Application for a non-material amendment following a grant of planning permission.

Replacement of unauthorised existing flat roof with a new pitched roof over a ground floor south facing outrigger. Resubmission of 3/2020/0353 & 3/2020/0895.

Reference number: 3/2021/0032

Amendment to vary the given drawing numbers and change the proposed overhanging gutter detail along the party wall between properties 2 and 4 Pendle Street West. The proposed design will include removal of the existing stone gutter and to replace for new powder coated profiled aluminium gutter at the head of the wall, with a drip flashing to conceal the junction between the two.

Drawing Title
Proposed Sections and Elevations
Project
2 Pendle Street West, Sabden
Client
Jigsaw Homes Group
Scales @ A1
1:50
First Issue Date
08/04/2020
RIBA Stage - Drawing Status
[3] - Planning
Drawn
BB
Check
BY

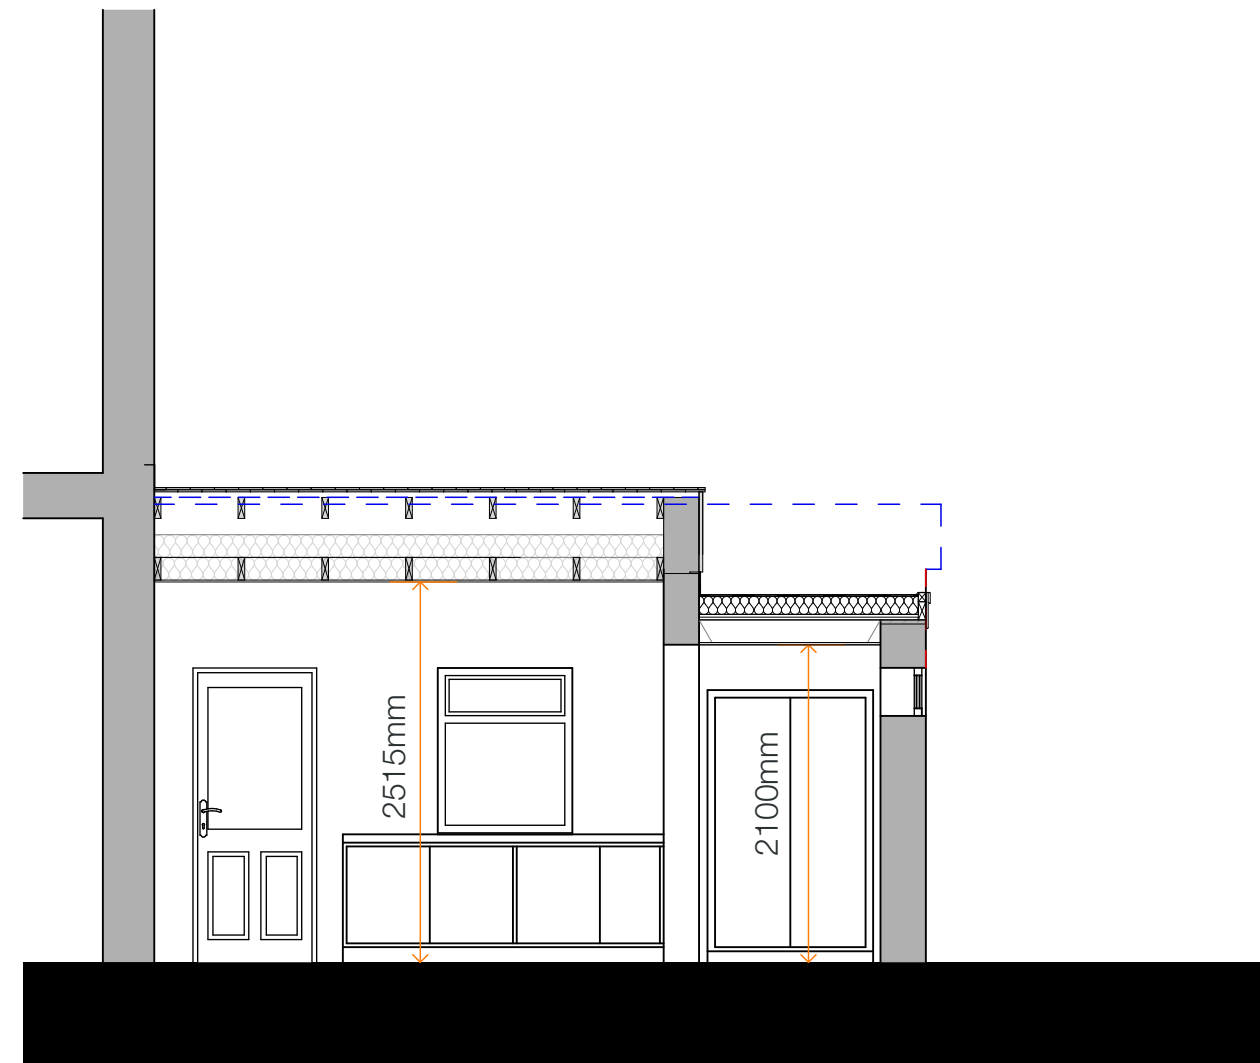
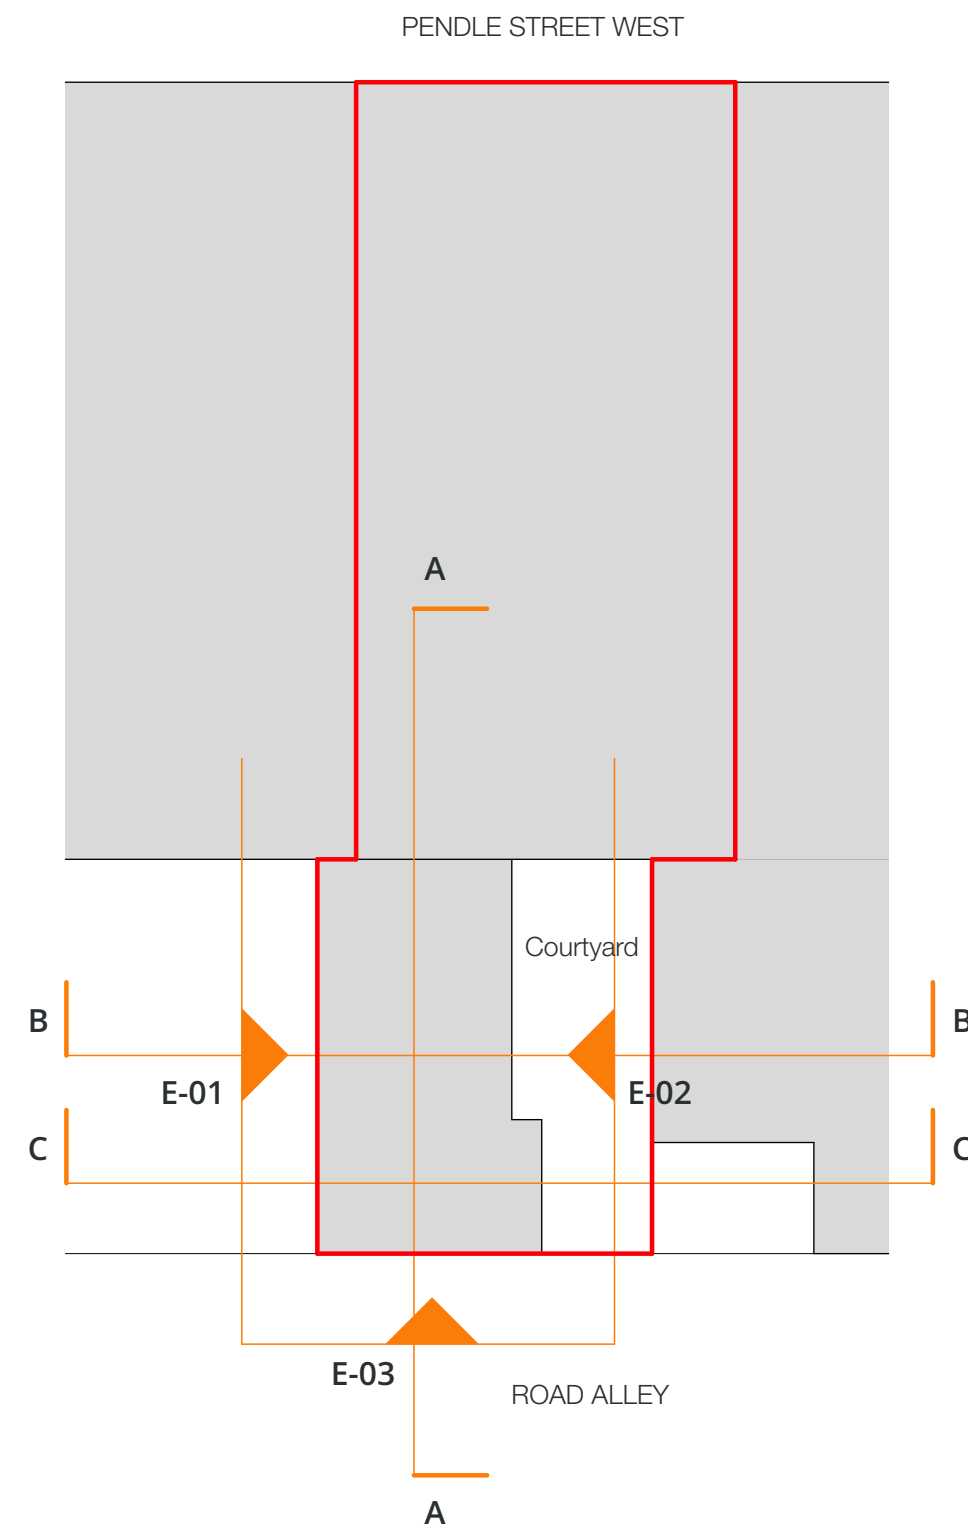
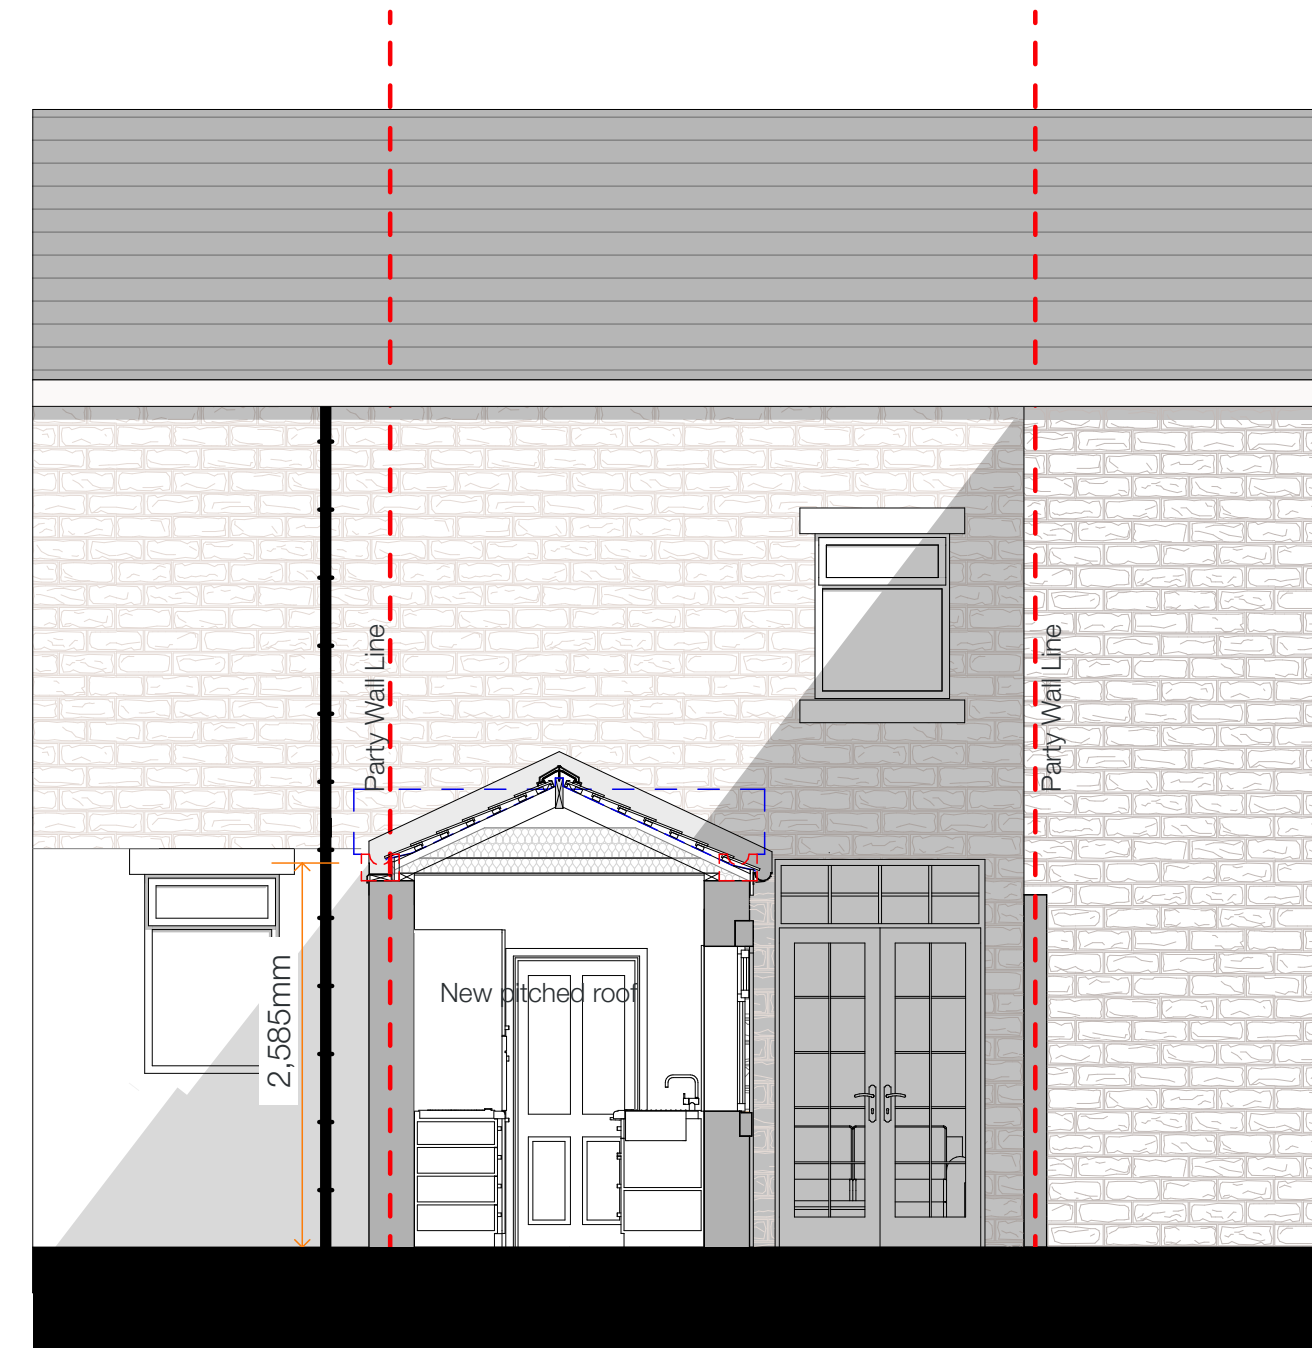
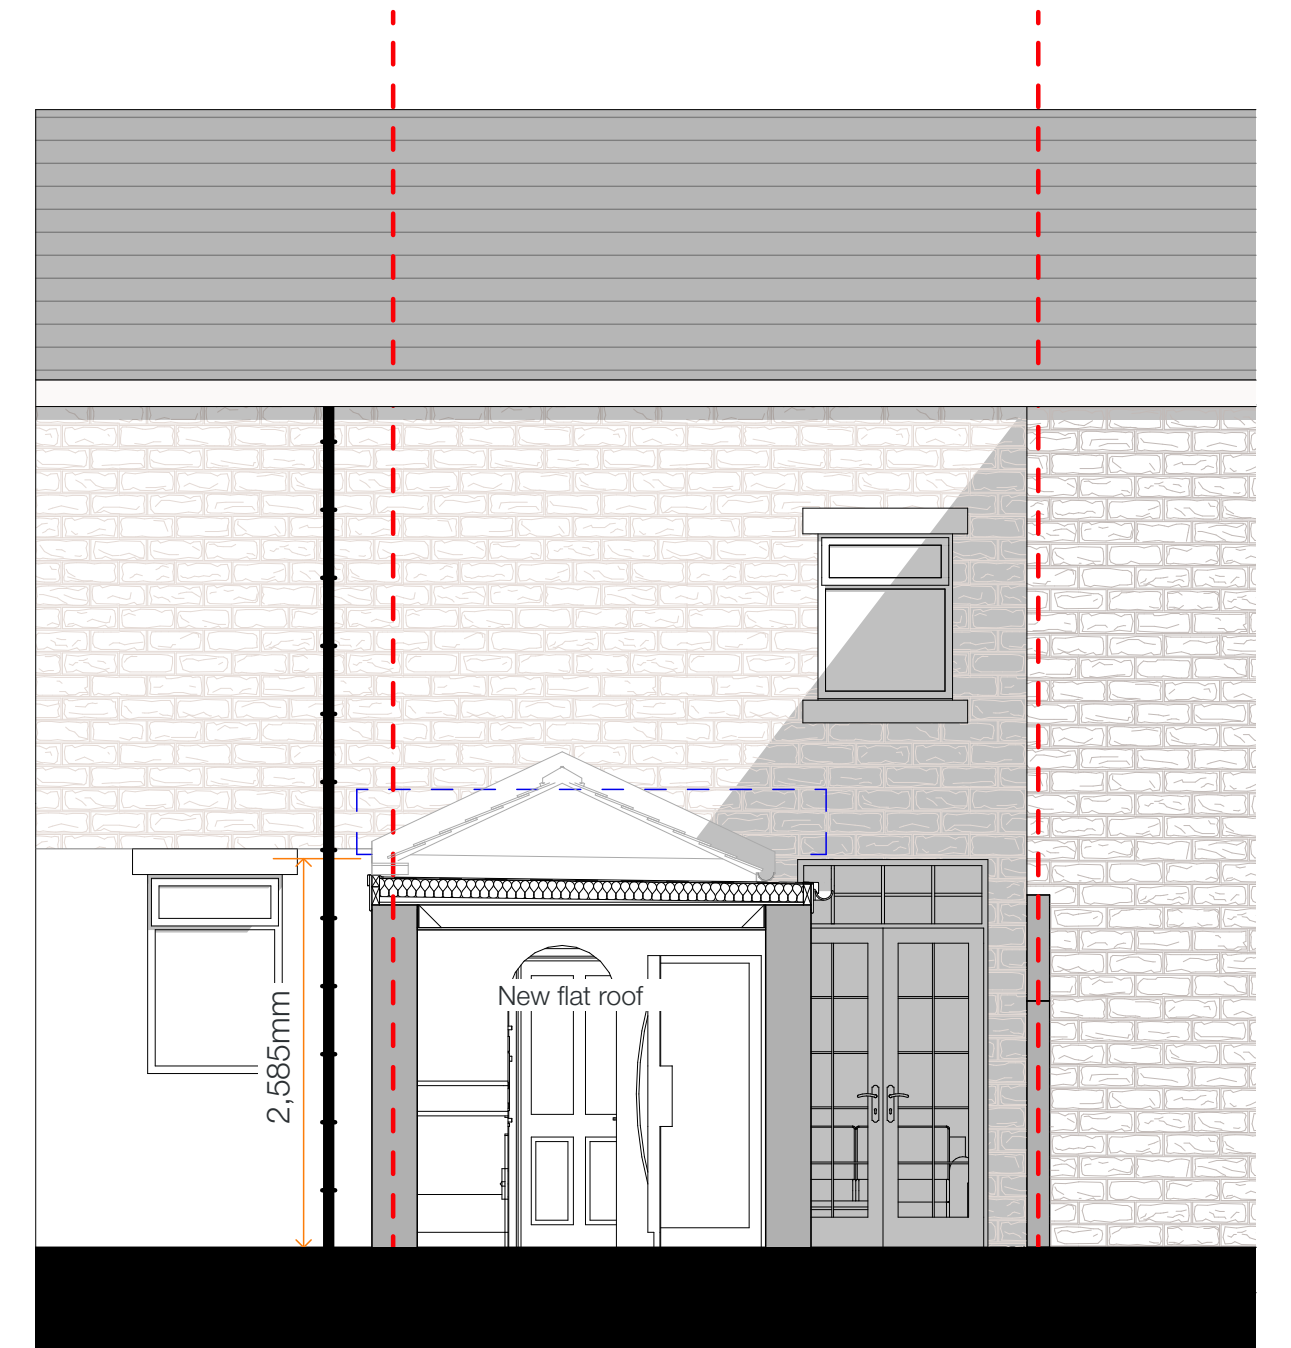
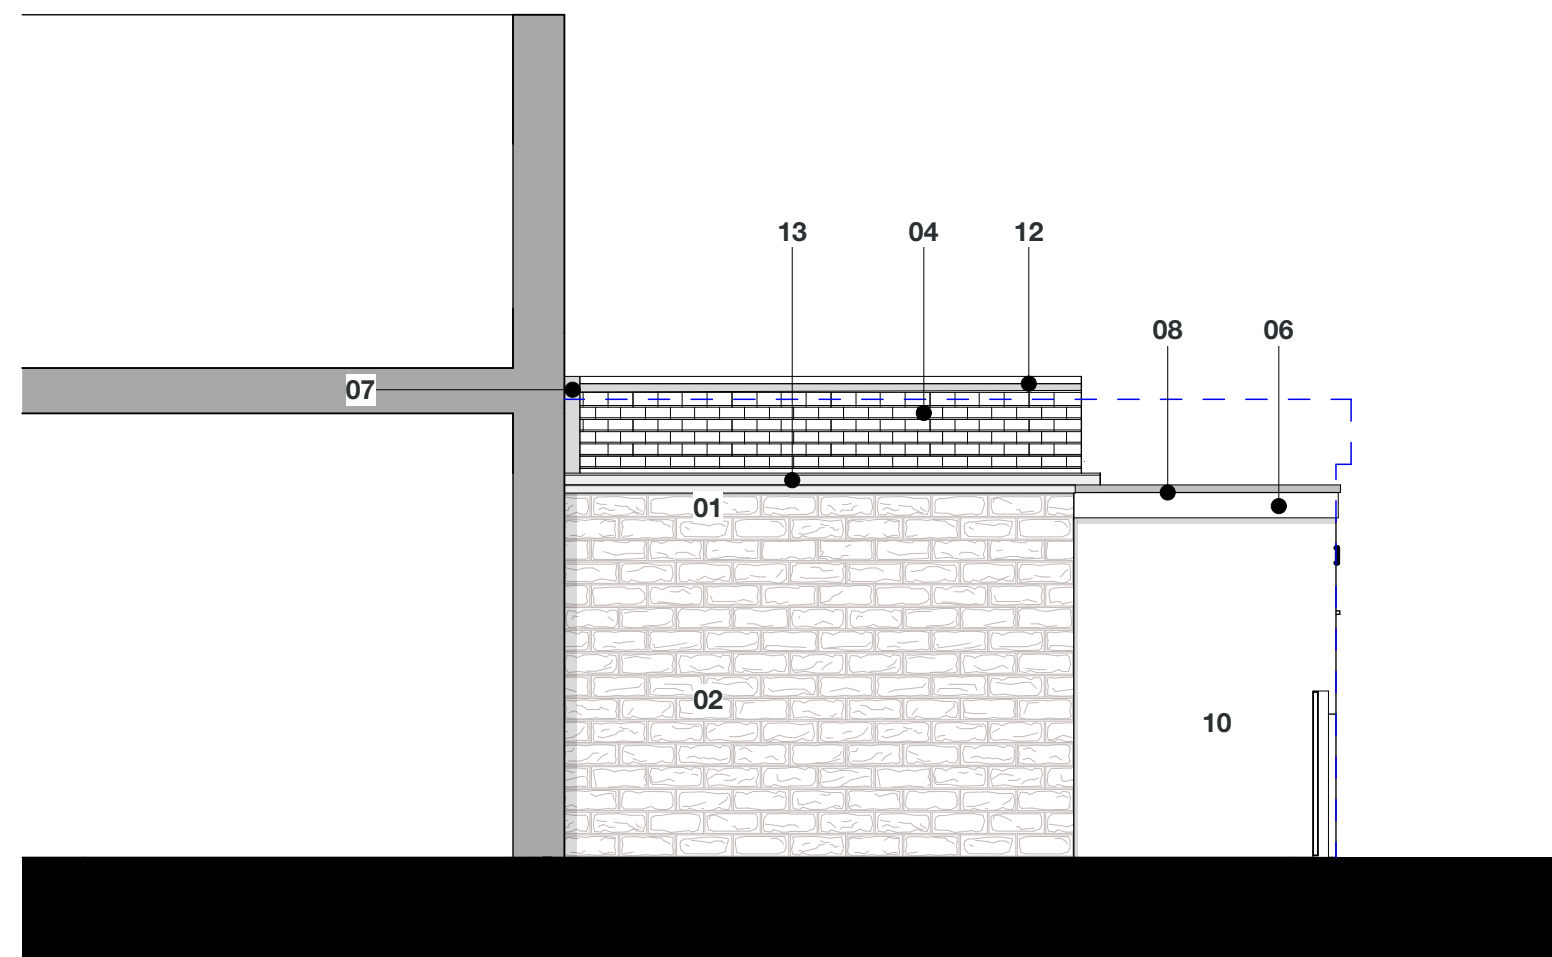
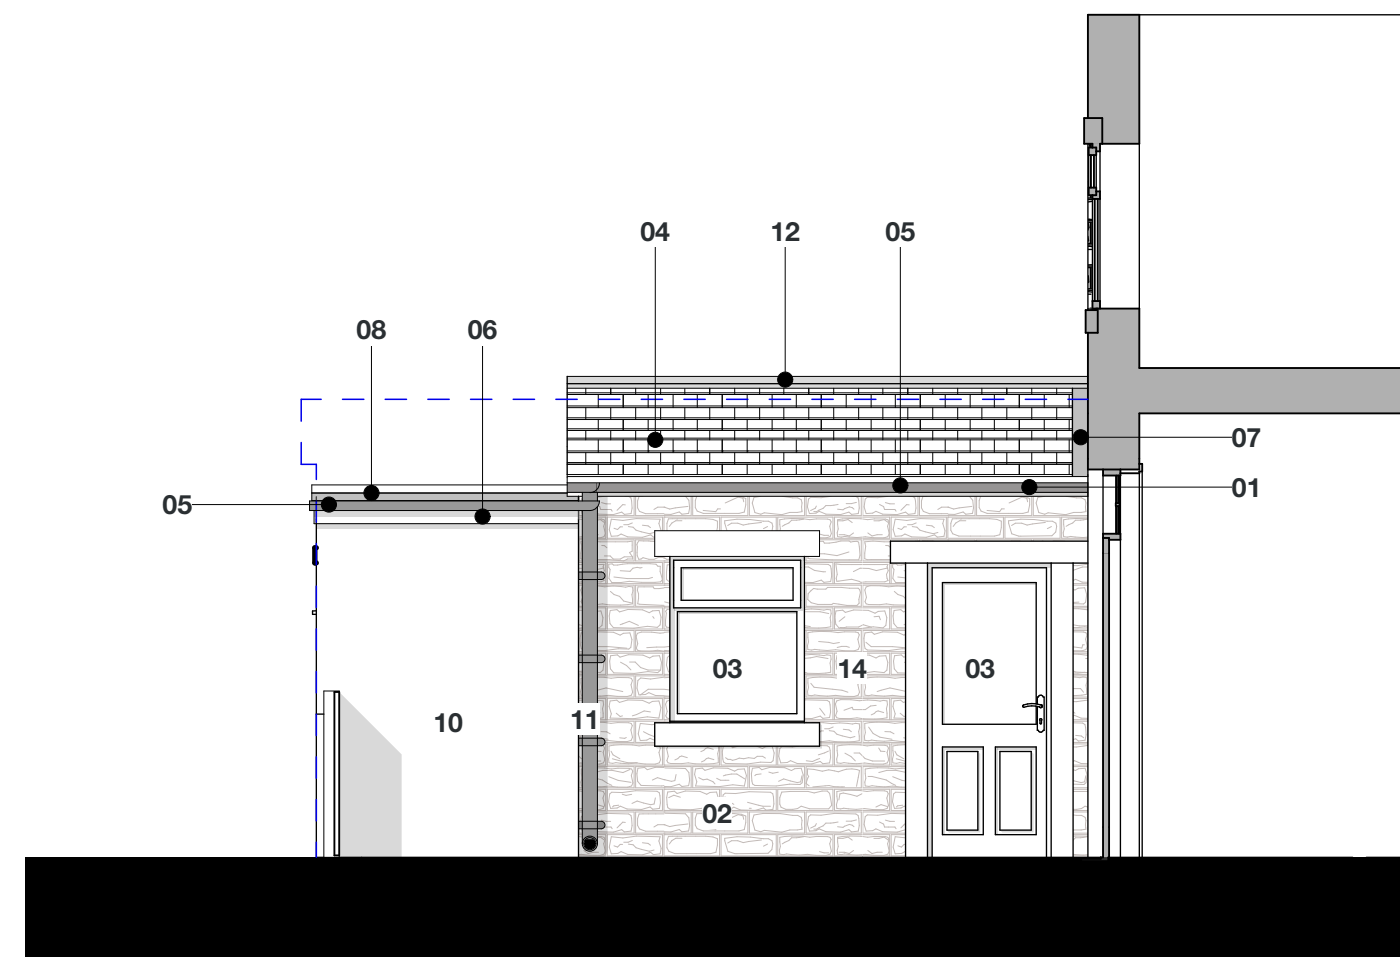
Concerns have been raised by the adjoining owner about the maintenance and visual aesthetic of the approved design which features and overhanging gutter along the party wall. The proposed solution is to replace this for a flush mounted gutter at the head of the wall. To minimise the visual impact of the proposals, the existing stone gutter will be removed and the top of the wall made good with the new gutter fixed in place and laid to falls. A colour matched aluminium drip flashing will cover any gaps between the new gutter and masonry below. All as per the details on the submitted drawings.
